Application for Planning Permission for Works or Extension to a Dwelling

Development: Single storey rear extension to replace existing conservatory with revised roof to existing single storey extension, first floor rear extensions, single storey glazed canopy to south side elevation

Location: Gulls 7 First Avenue Felpham PO22 7LG

Proposed South

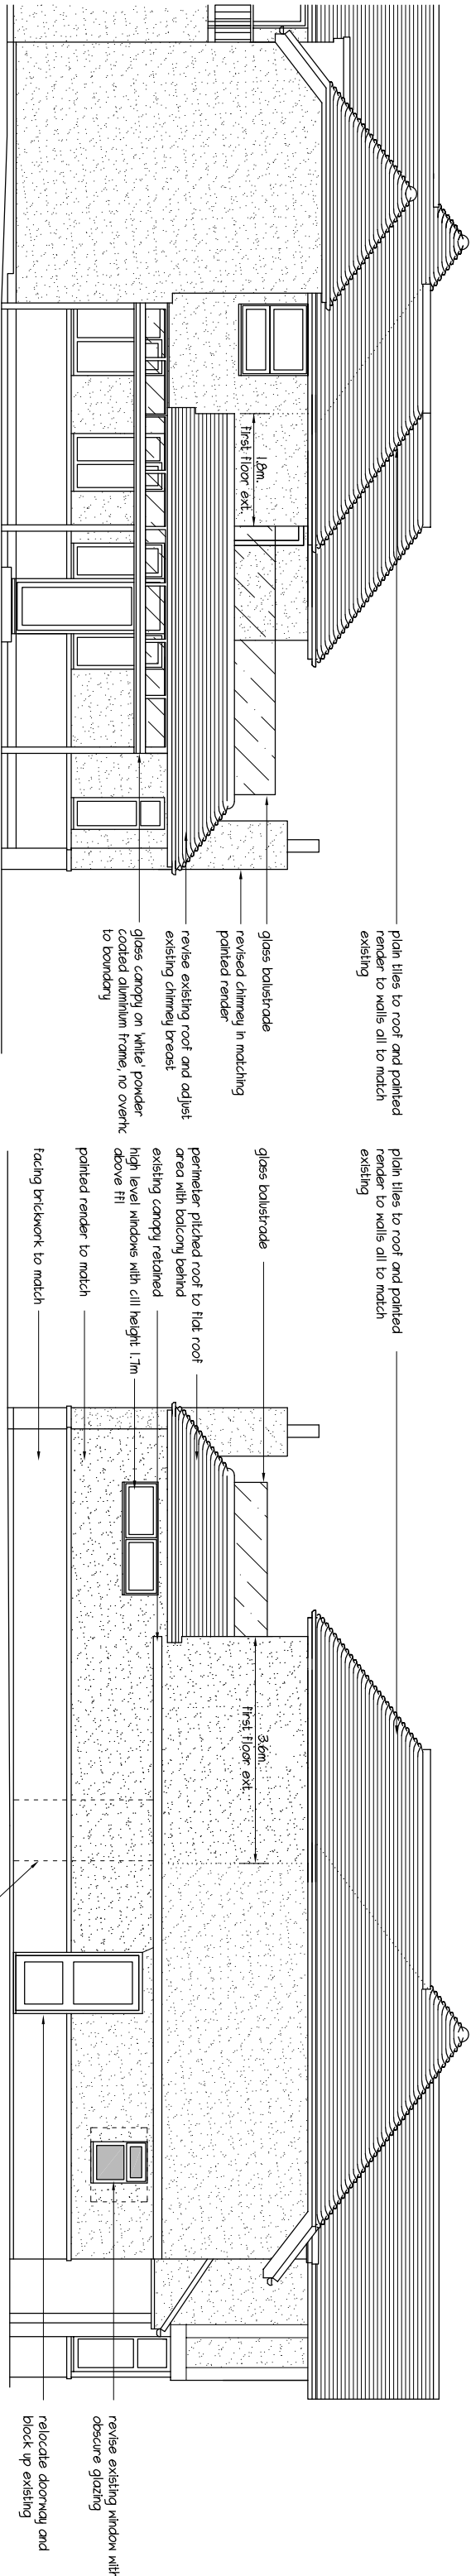
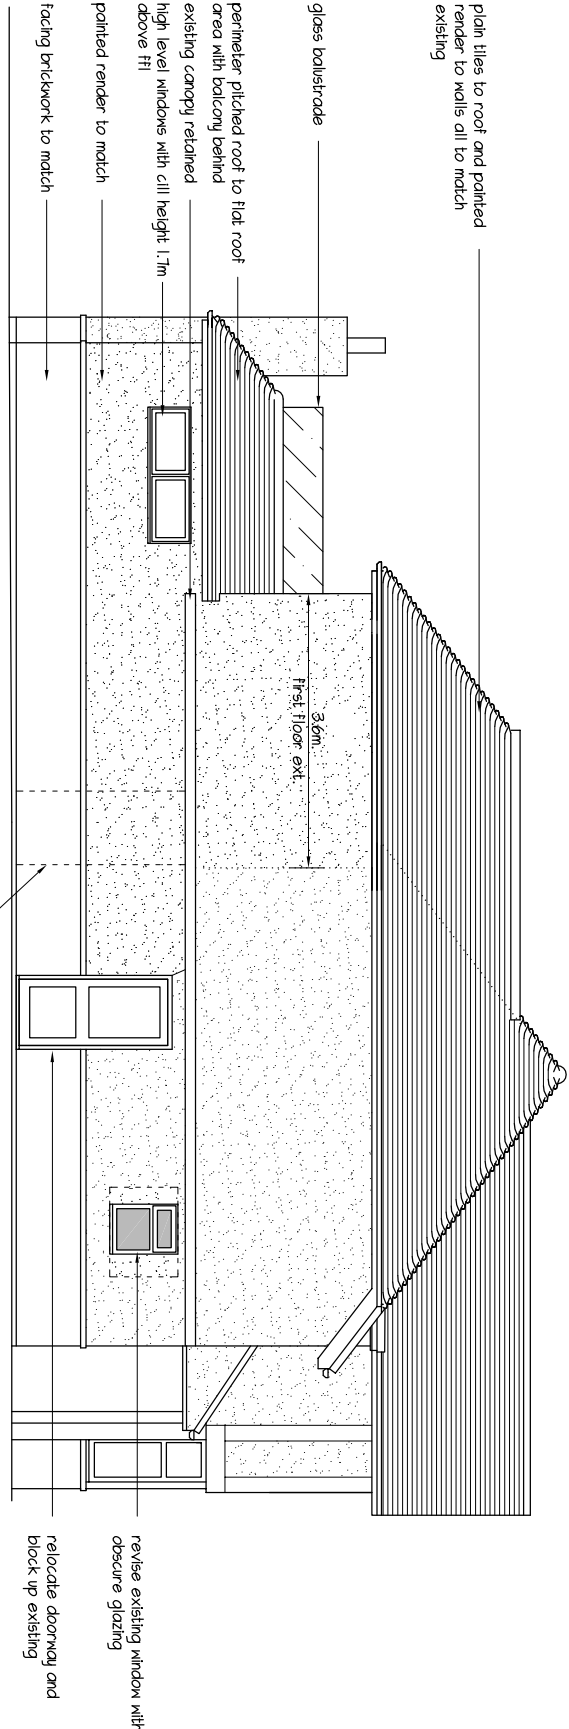
Other Side Elevation: Please provide the other side elevation for this proposal.

Block

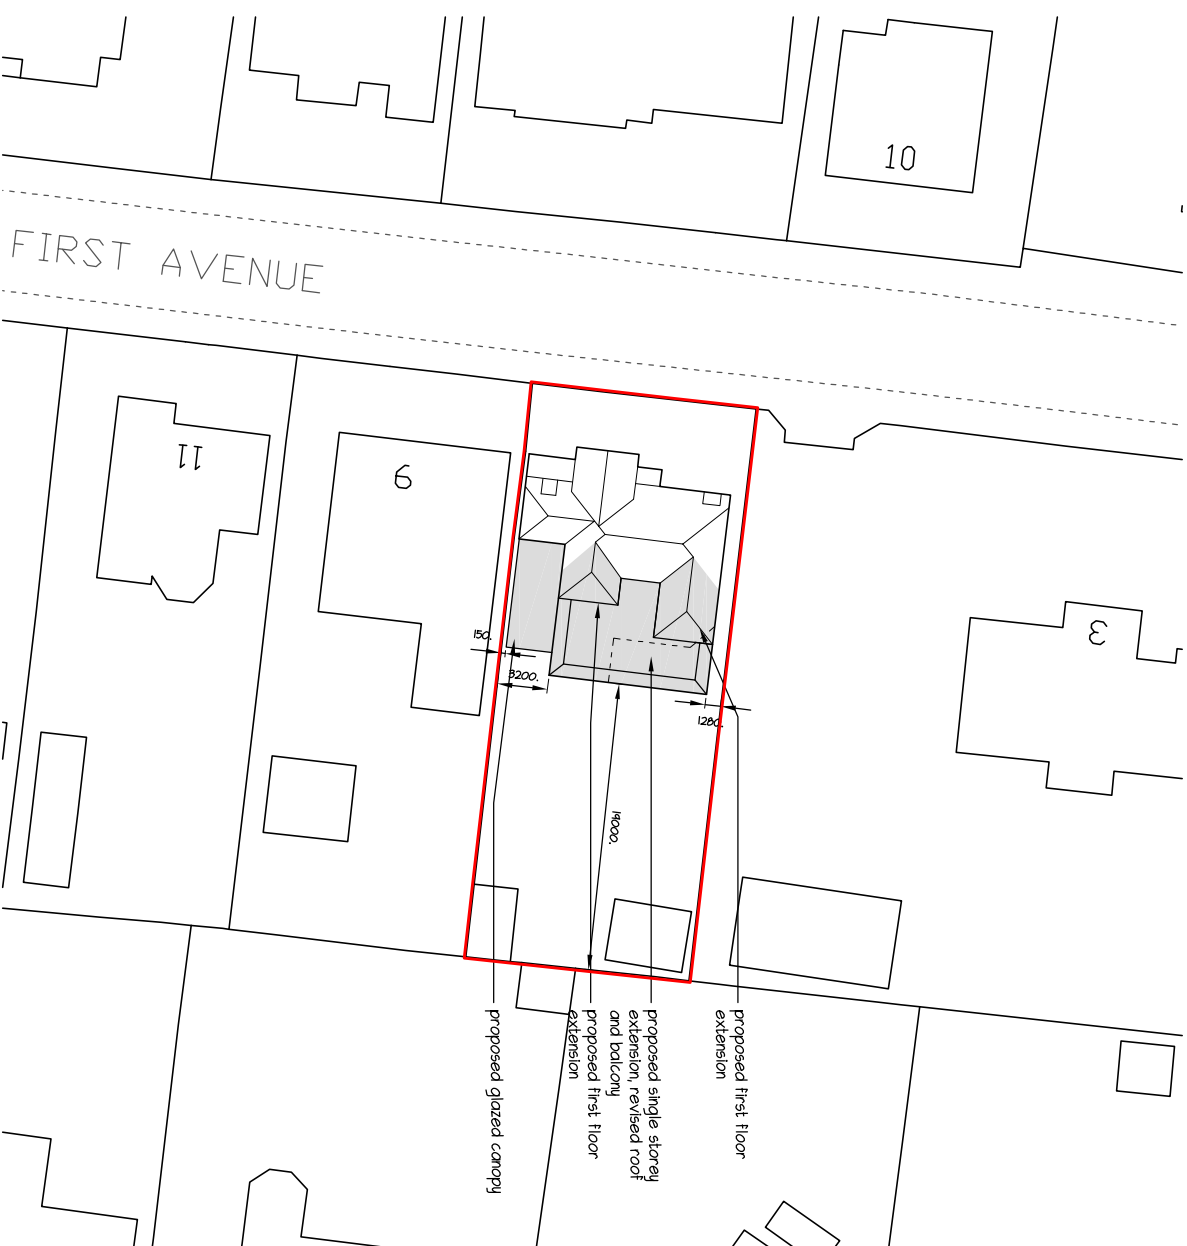
Dimensions: You are required to include dimensions from the proposed extension to all site boundaries on the block plan.
